From: Laura Gibbons
Sent: 19 November 2018 11:21
To: Simon Davis
Subject: RE: Soakaway location BE/88/18/DOC

Comments Regarding Condition 3

Detail: Foul and SW drainage

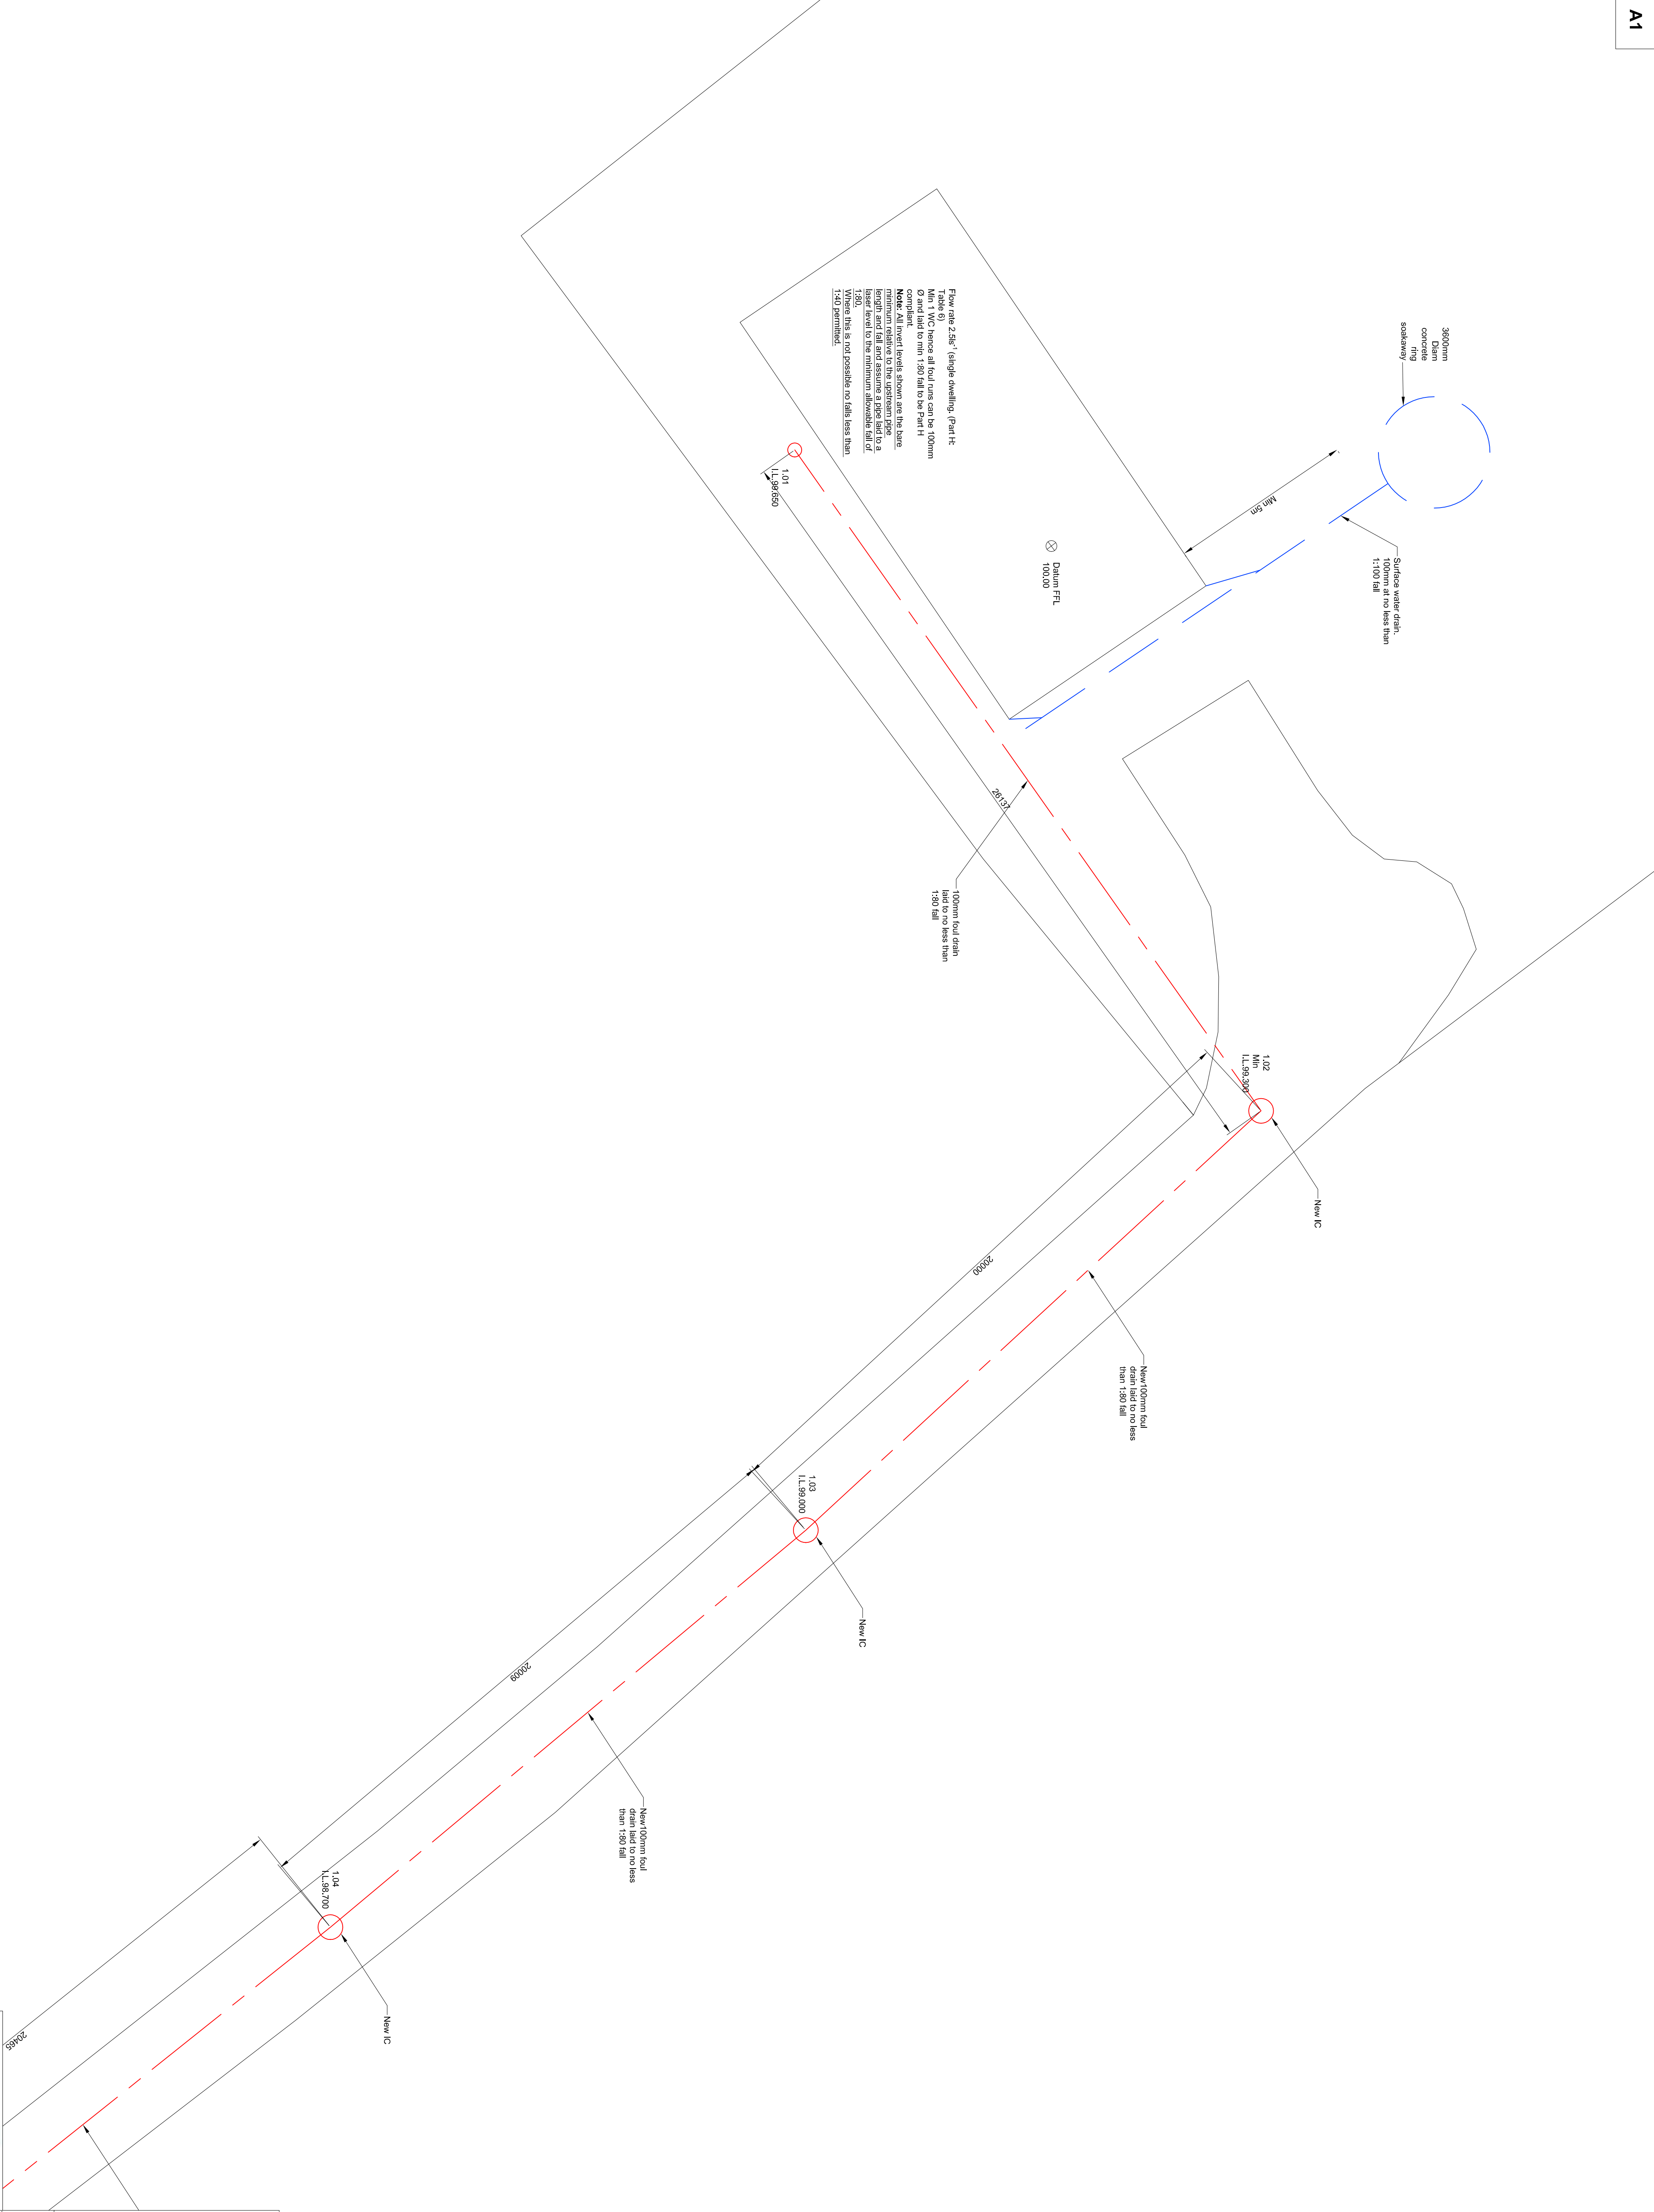
The soakaway depth and size is fine. However there are still some points which need to be rectified. The plastic pipe which connects from the down pipe to the soakaway needs to have concrete bed and surround. Also, a catchpit needs to be provided upstream of the soakaway.
